University of Newcastle, Honeysuckle City Campus Concept Proposal (SSD 9262)

I refer to your letter dated 30 July 2018 seeking comments from the Heritage Division on the abovementioned development proposal. The proposed development site is located at 16, 16A and 16B Honeysuckle Drive, 20B Wright Lane and 430 Hunter Street in the Newcastle Local Government Area.

**Referral of Development Application DA2018/00578 – 430 Hunter Street, Newcastle
Former Civic Station – Part demolition of structures, alterations and additions to station
building for adaptive re-use, associated landscaping and one lot into two lot subdivision**

Figure 3.6 Setbacks Diagram

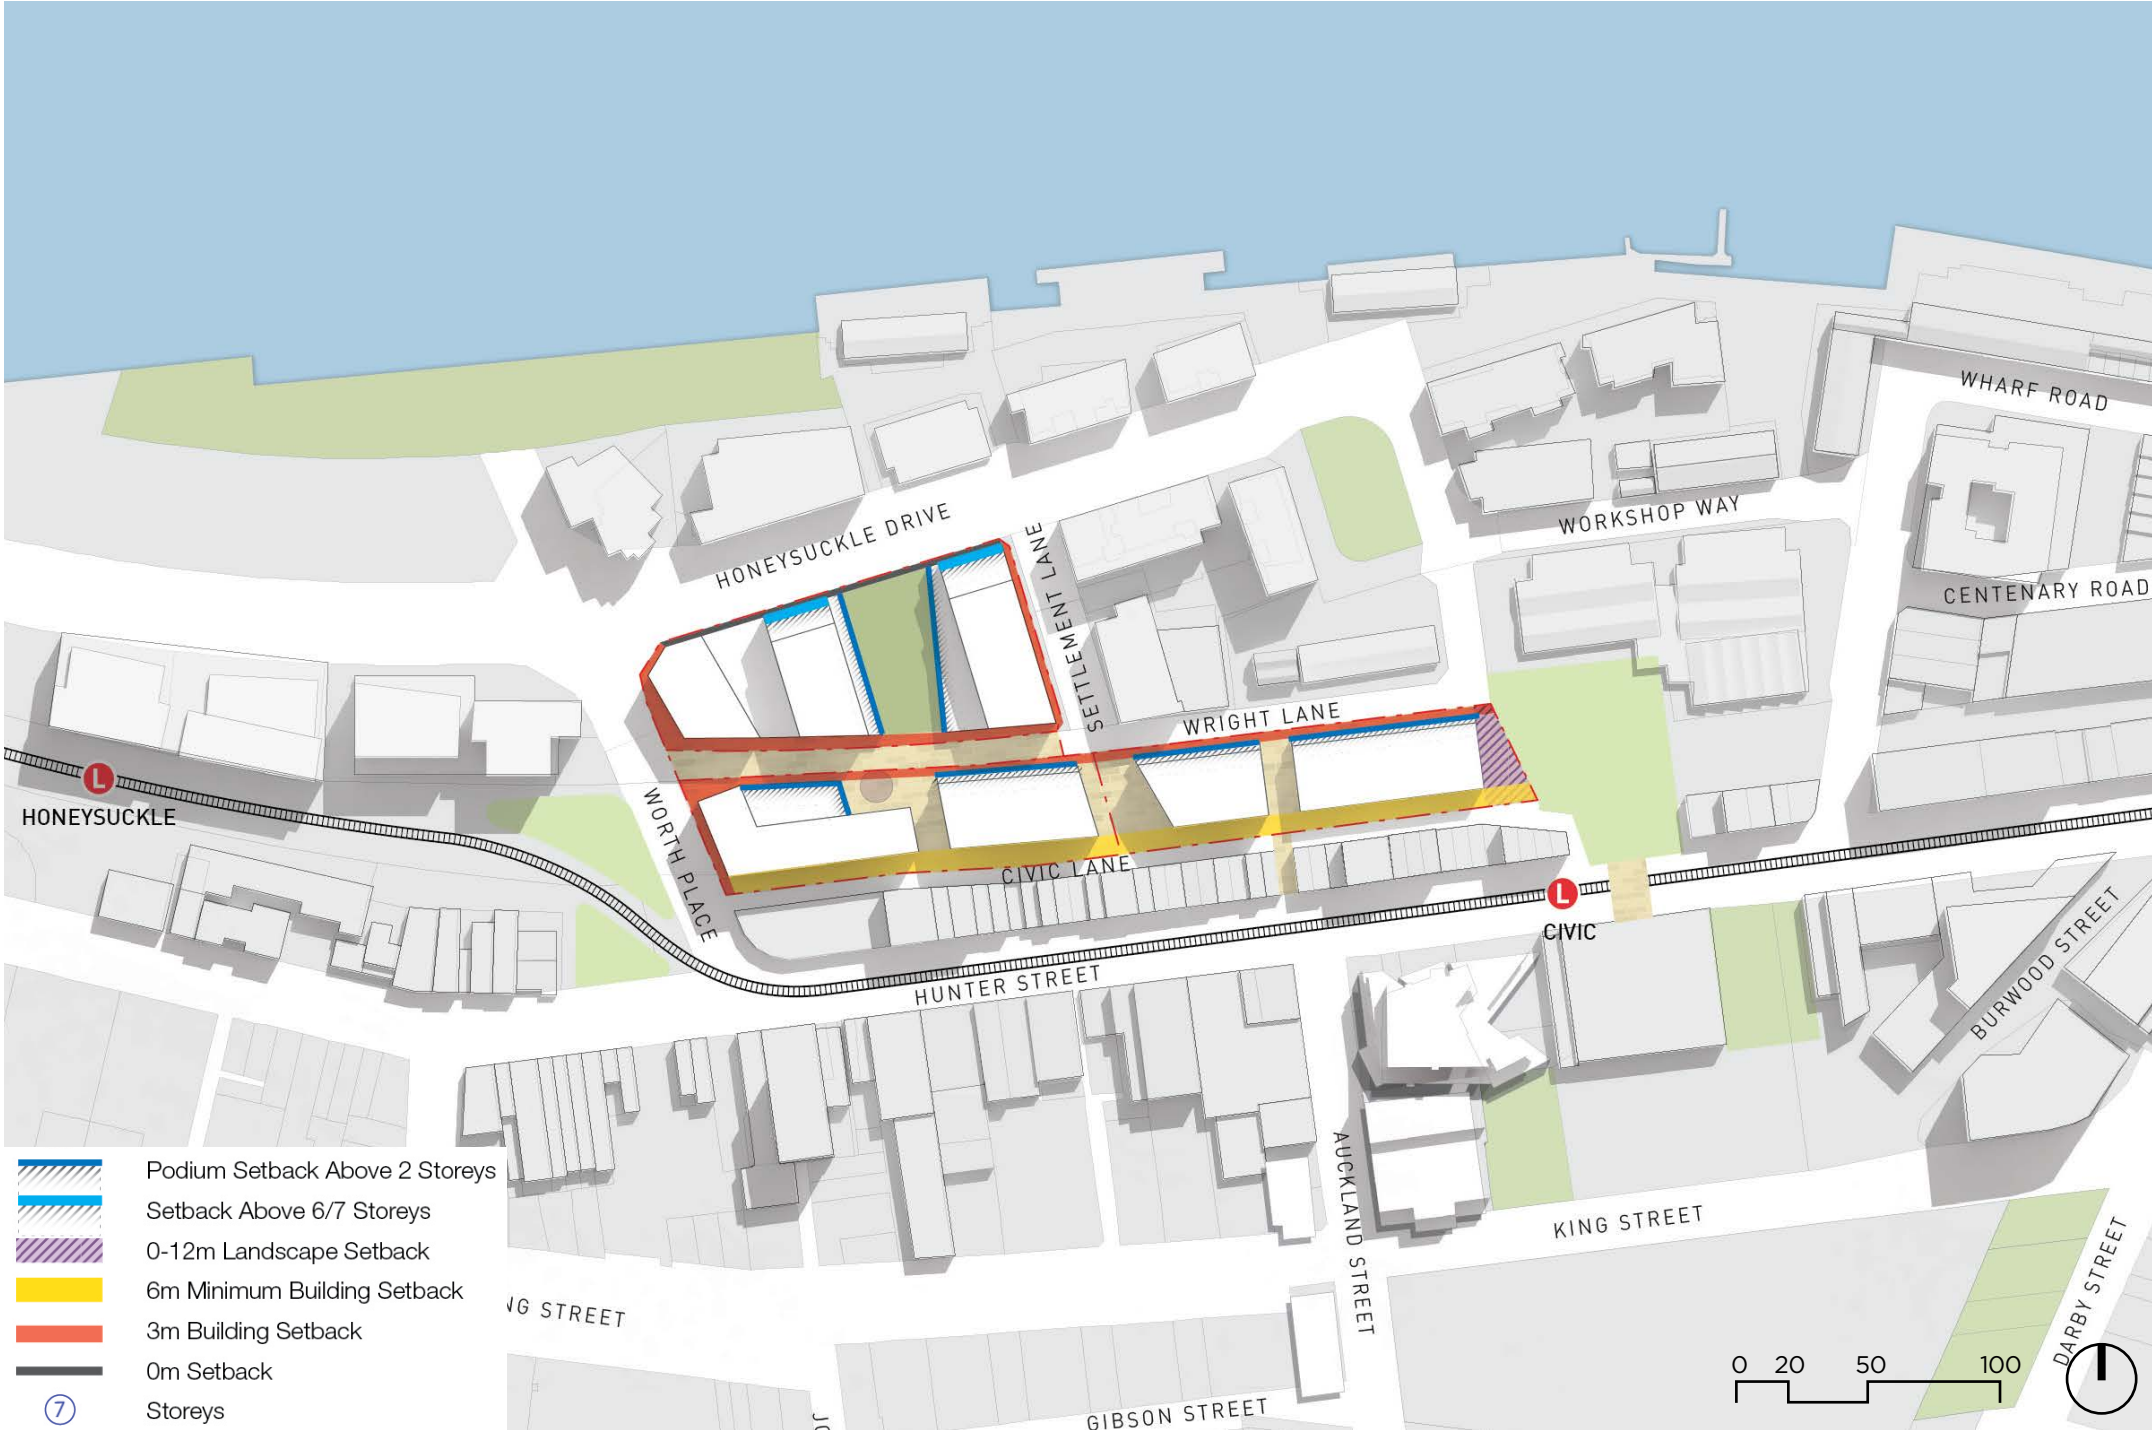
The proposed Site 3 impinges on the curtilage of the SHR listed 'Civil Railway Workshops'. The curtilage of the 'Civil Railway Workshops' includes the Wright Lane and the existing parking space to the south of it. The Site 3 also includes the western platforms of the Civic Railway Station Group. Heritage Council under delegation provided a response dated (11 July 2018) (See Attachment A) in response to a referral for a Development Application for the redevelopment and adaptive reuse of Civic Railway Station, which includes the demolition of the western platforms included in Site 3.

While few recent developments around the 'Civic Railway Workshops' have had some visual impact on the significance of the heritage item, due to the largely open character of the proposed Site 3 location, the historic setting of the 'Civil Railway Workshops' to the south has largely remained intact. Any development on the proposed Site 3 will have adverse impact on the setting of the Civil Railway Workshops.

The development on Site 3 is proposed to be set back 3m from Wright Lane while the higher floors above the 2-storey podium will be set back further 3m.

1. It is recommended that the concept plan be revised to remove the proposed intrusion into the SHR curtilage to avoid the visual impact and impact on the setting of the Civic Railway Workshops.
2. It is recommended that the high reflective surfaces, large areas of unshaded glass and bright white finishes should be avoided. External colours should be subdued and take inspiration from the colours of the locality.

Figure 7.7 Lot B Detail Plan

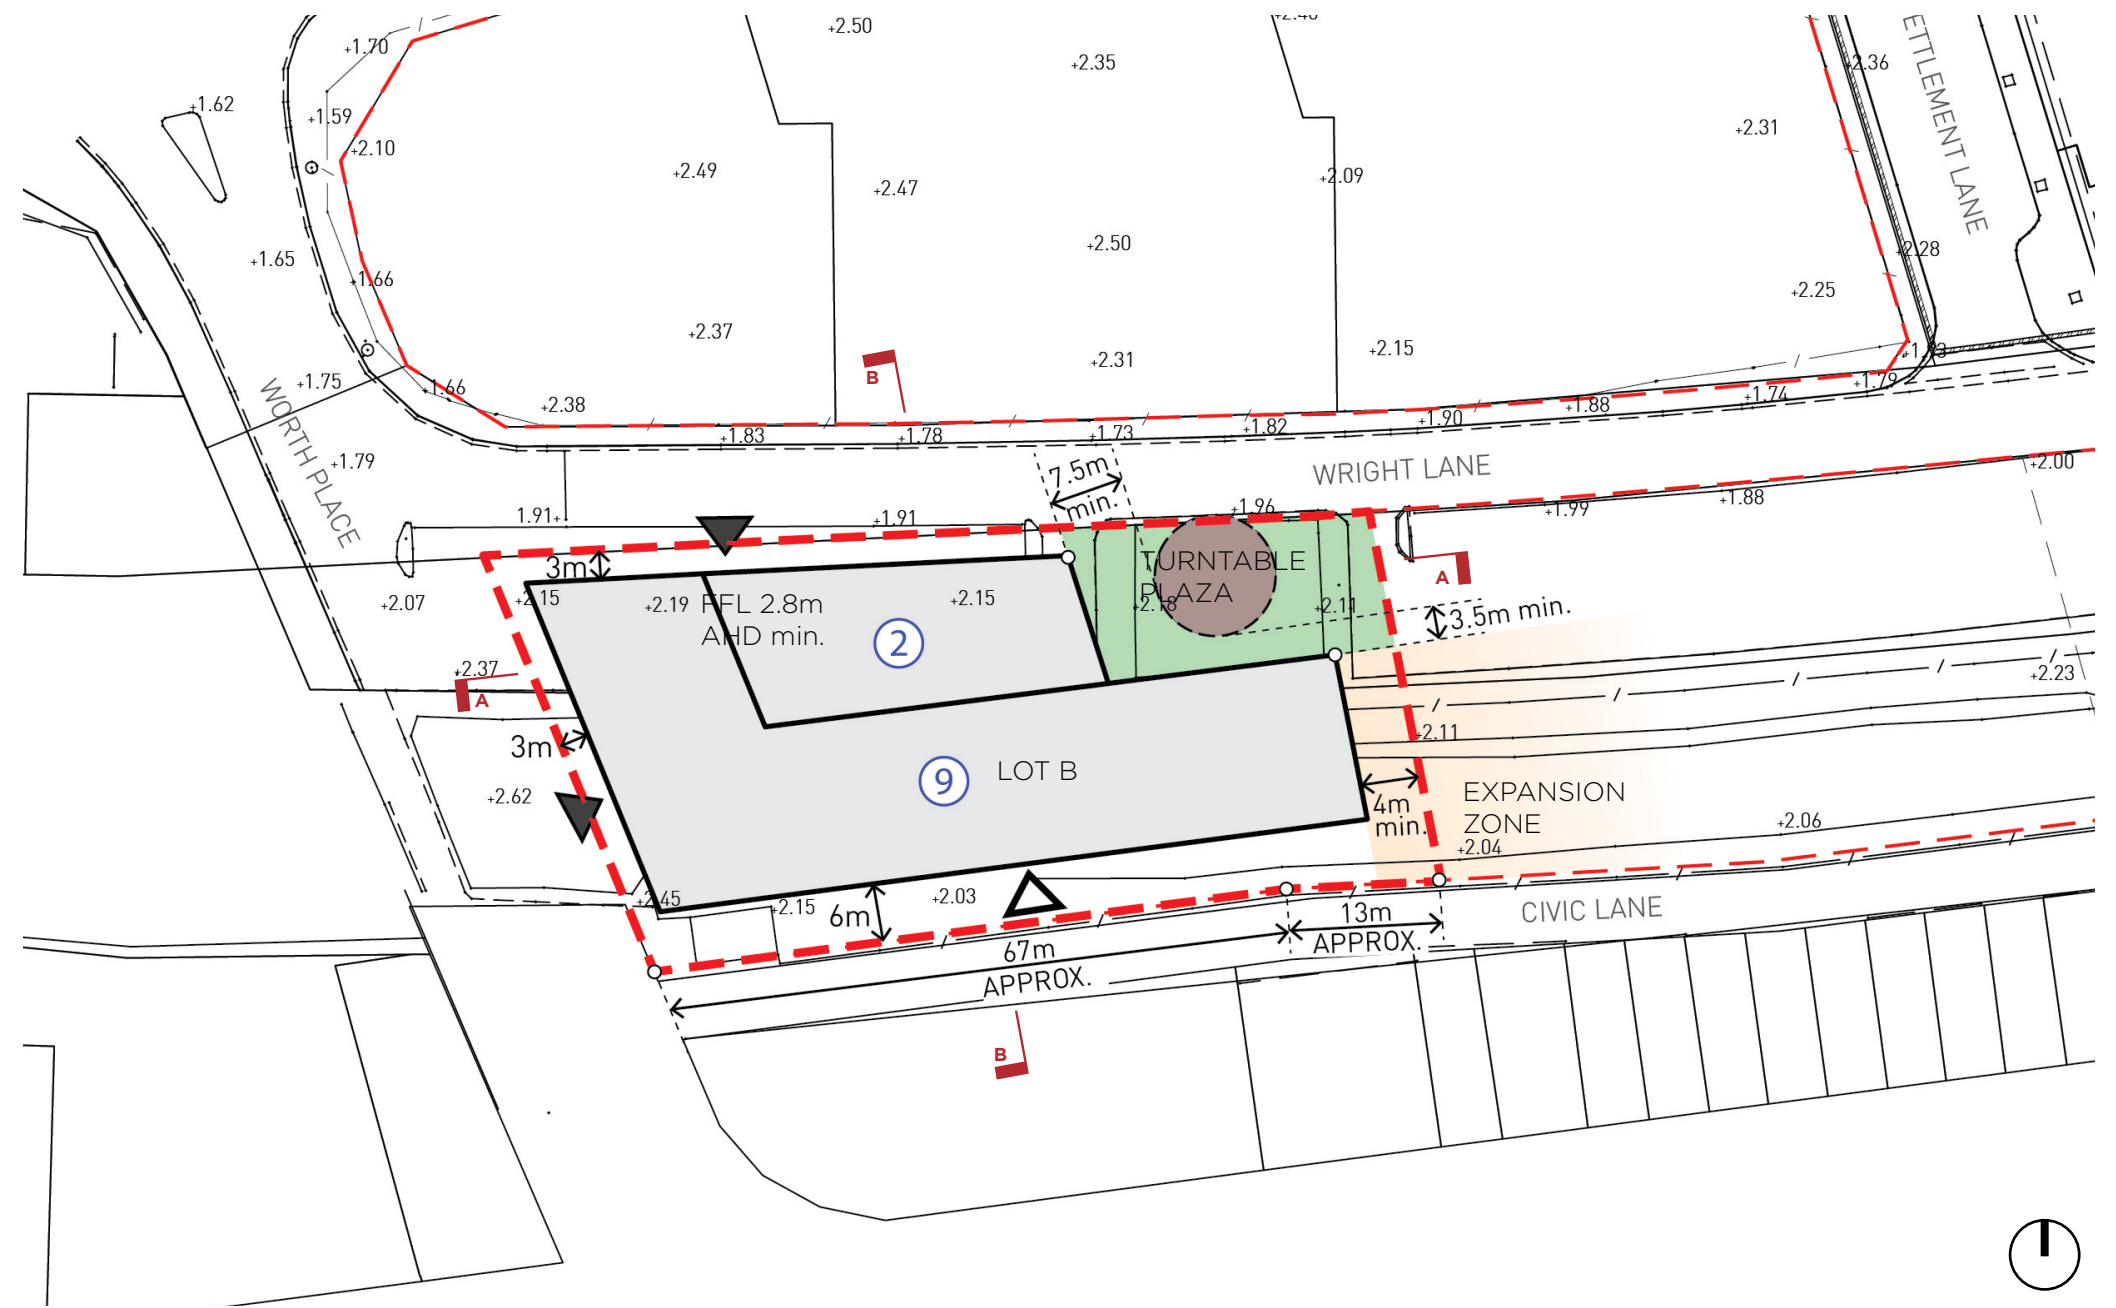
It is also noted that the site contains the in-situ remains of the Engine Turntable within site 2. The recommendation to retain this work in-situ is supported.

Figure 7.13 Lot D Detail Plan

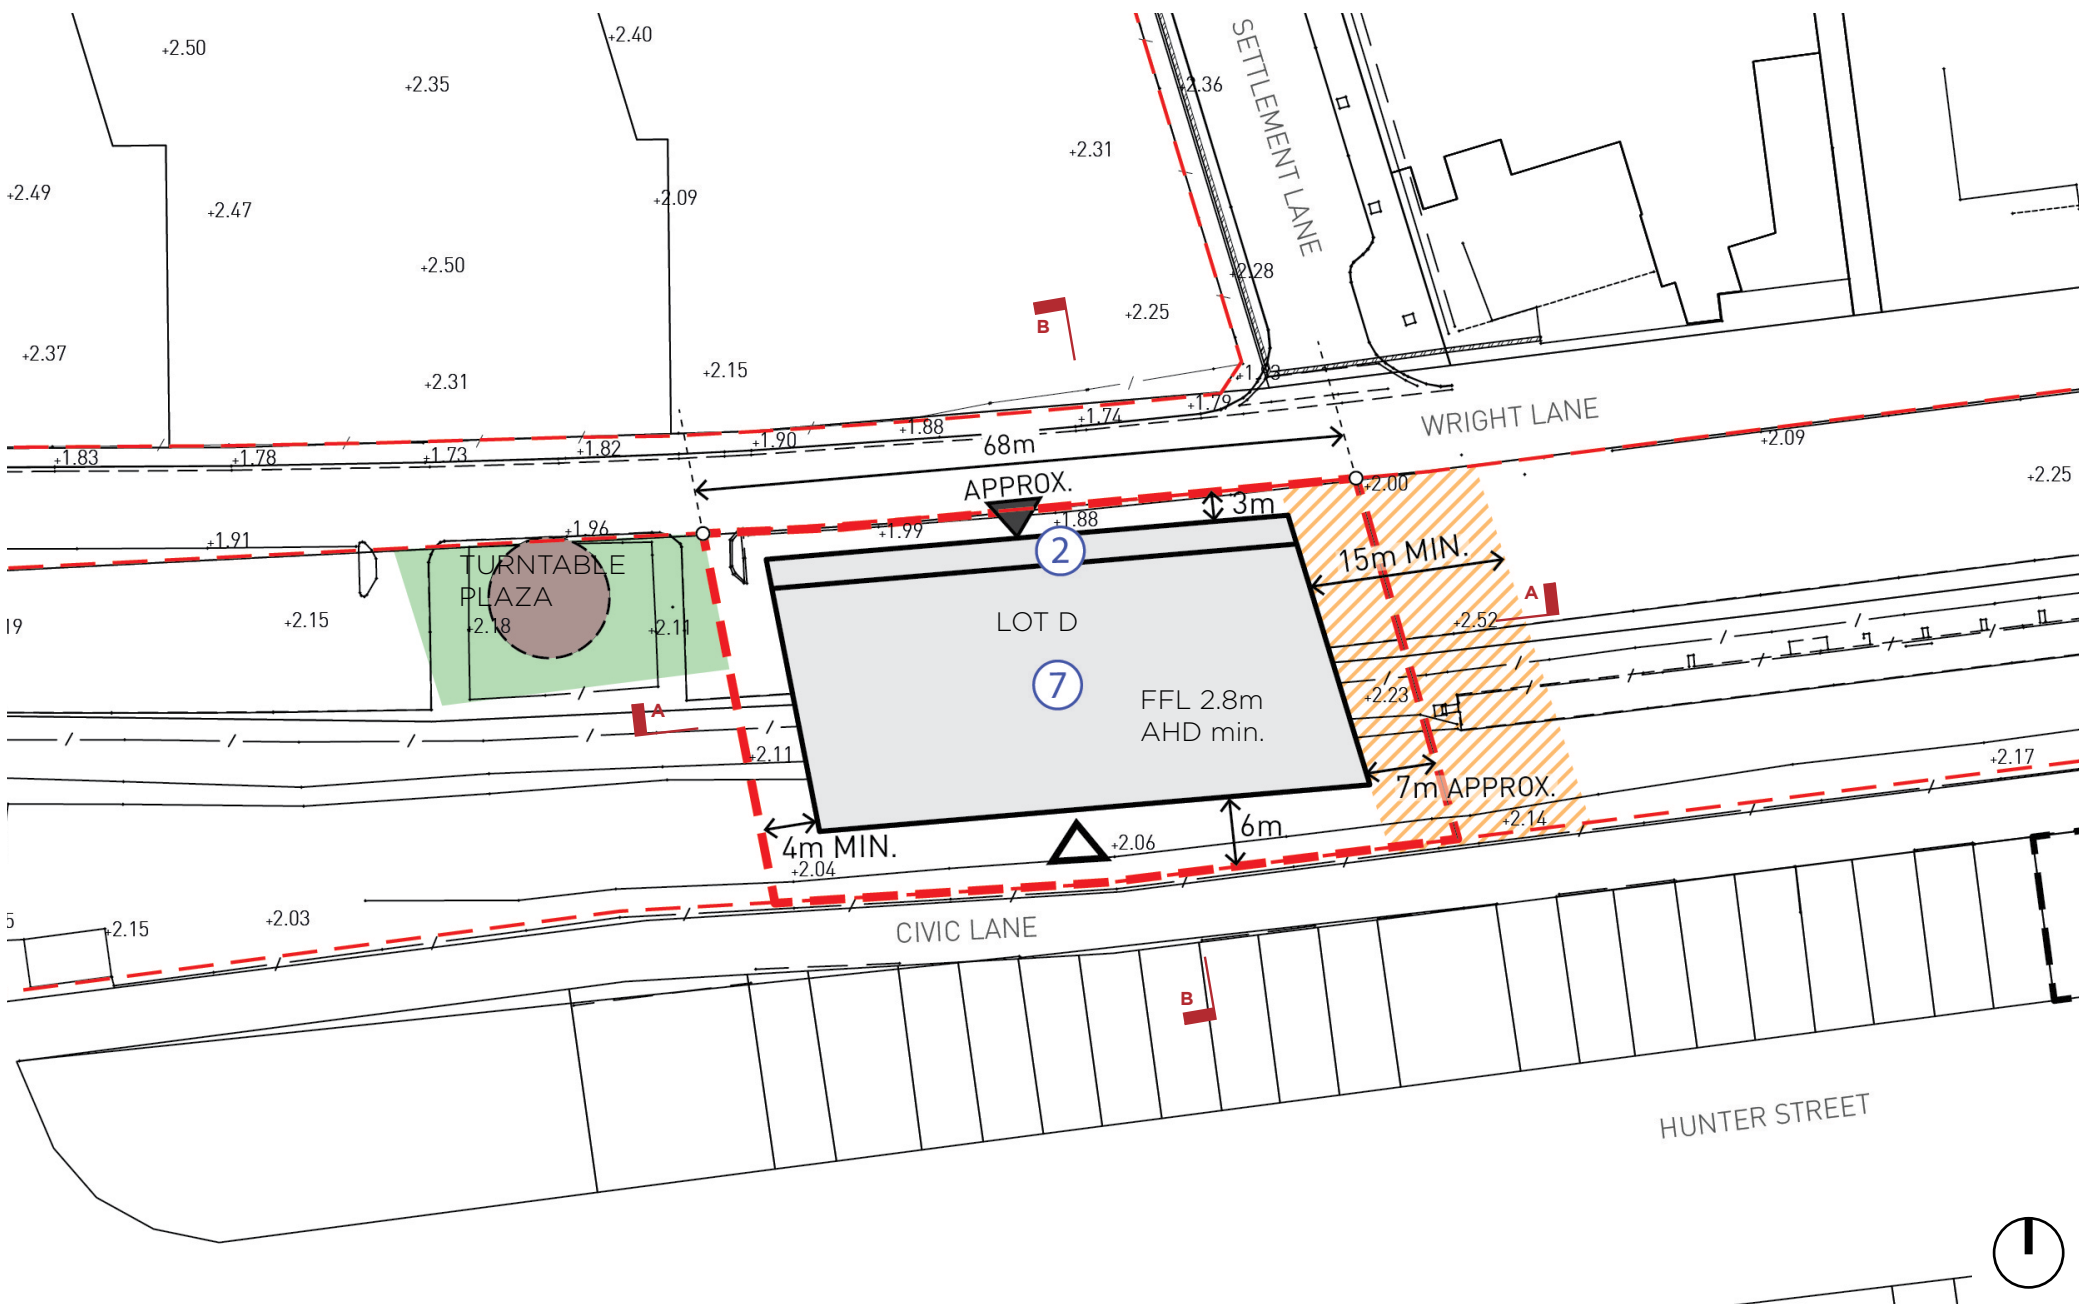
The main views that will be impacted by the HCCD development will be views from and to the 'Civic Railway Workshops', particularly on the eastern side of the study area (Site 3) to the north of which is the 'Divisional Engineers Office/Boiler House'. The remaining 'Civic Railway' buildings (now Museum of Newcastle) are located to the east/northeast of Site 3. Therefore, to mitigate the visual impact, development especially on Site 3 and 2, should have sympathetic building form, finishing and adequate setback from the State listed item.
